Recommendation Report for Planning Permission for Works or Extension to a Dwelling

REF NO: AB/40/22/HH

LOCATION: Coachmans Cottage
Kings Arms Hill
Arundel
BN18 9BT

PROPOSAL: Two storey rear extension. This application affects the setting of listed buildings, affects the character & appearance of the Arundel Conservation Area.

PROPOSED ELEVATIONS

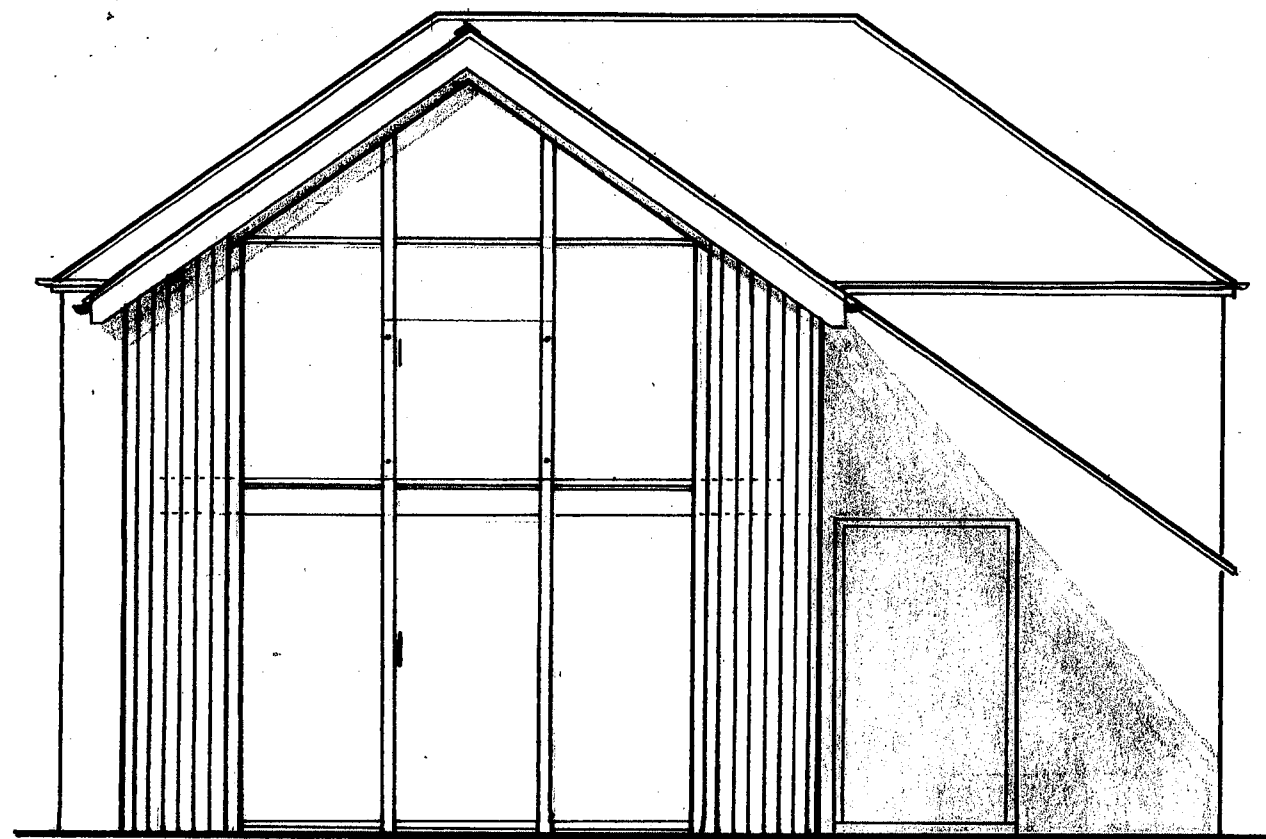
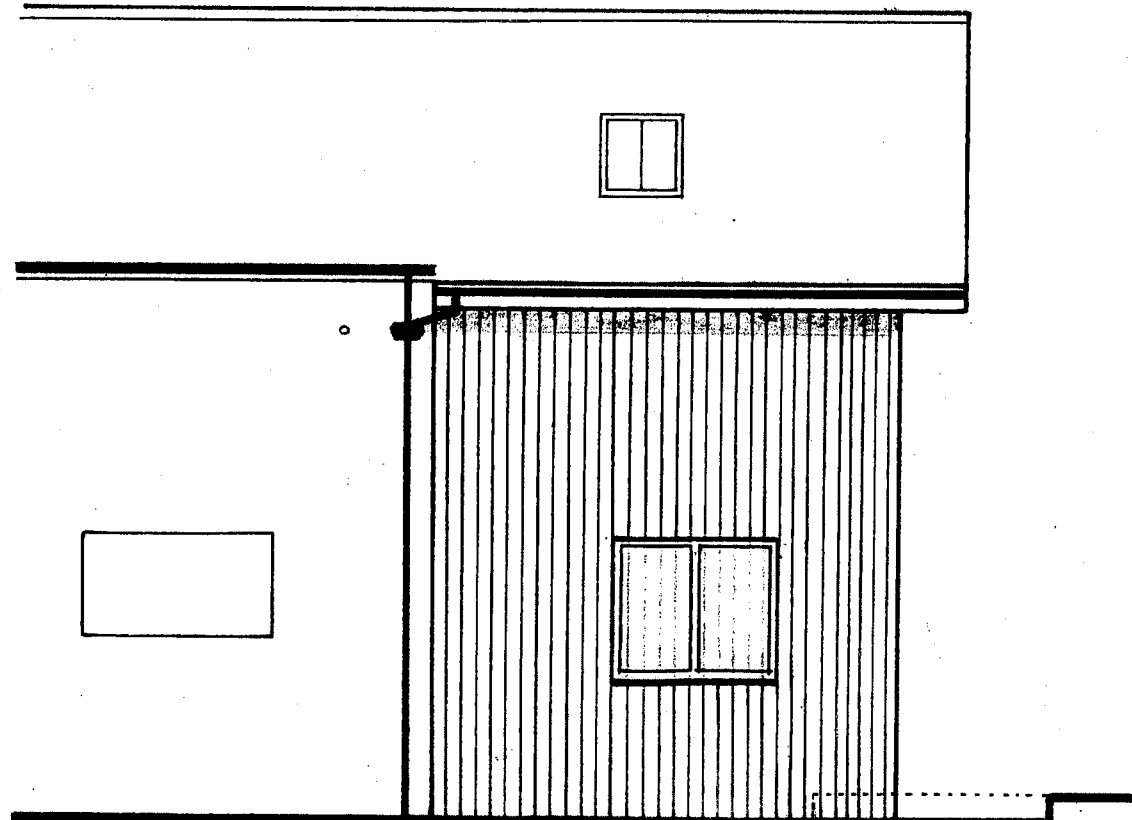
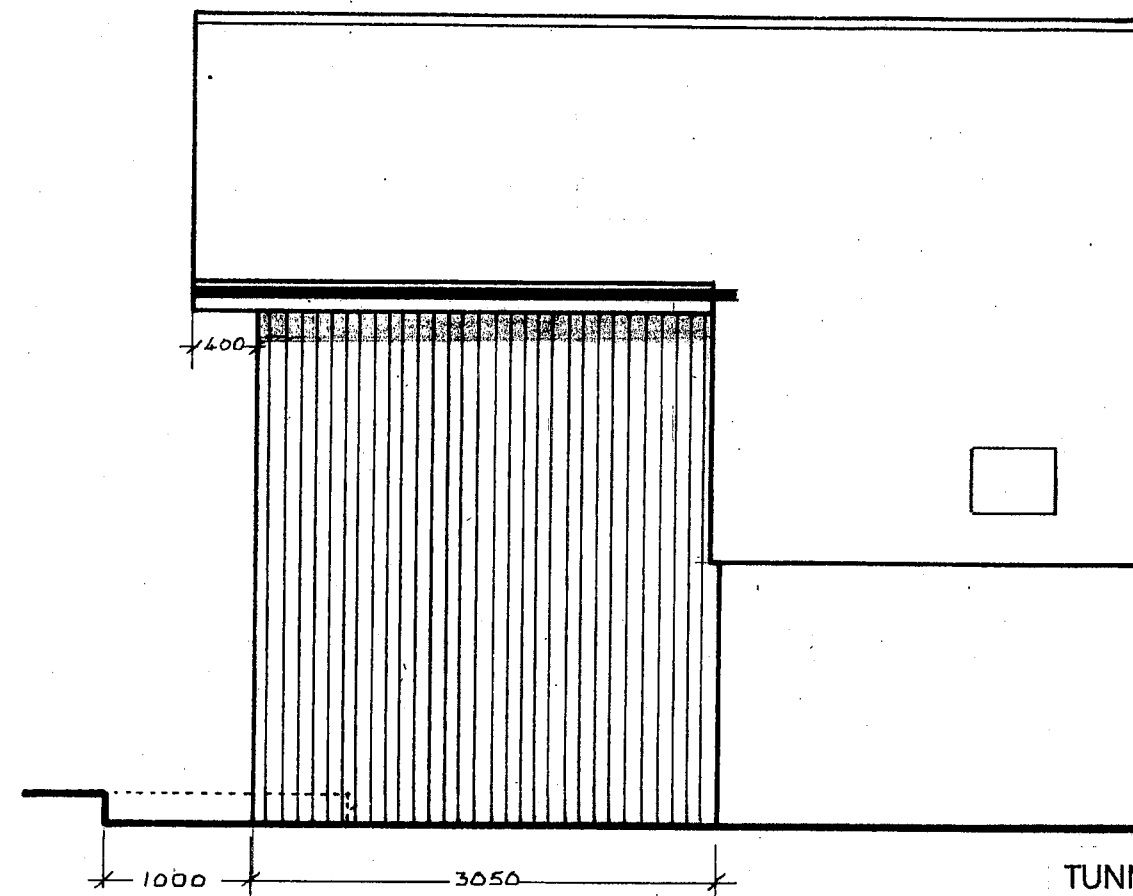
It has been noted that the submitted plans have been incorrectly labelled. The building fronts facing eastwards and as such the rear elevation should be annotated as the 'Western Elevation' and the sides of the building should be annotated as 'Northern and Southern Elevations' respectively. However, the information submitted with the application was sufficiently accurate to enable a decision to be reached. Throughout the report the elevations have been referred to correctly by the Officer.

By reason that the extension has a lower ridge height and lower eaves height it will appear subservient to the host building and as an extension to an existing property will not harm its established character.

It is proposed to build the extension with a contemporary pallet of materials and will include vertical cladding and a large section of glazing to the western elevation. The cladding will naturally oxidise and will create a bucolic feel to the design providing a complementary finish to the existing red brick elevations. The finish to the roof will match the existing. Although the proposed extension would obscure the existing western elevation it is noted that the existing elevation is not of historic importance, as such

In terms of overlooking a large, glazed gable-end has been proposed so most views achieve views overlooking the host dwelling private amenity space. A single conservation-area roof light has been proposed to the northern roof plane. As a result of its high level and good separation gaps between elevations no harm from overlooking will be caused.
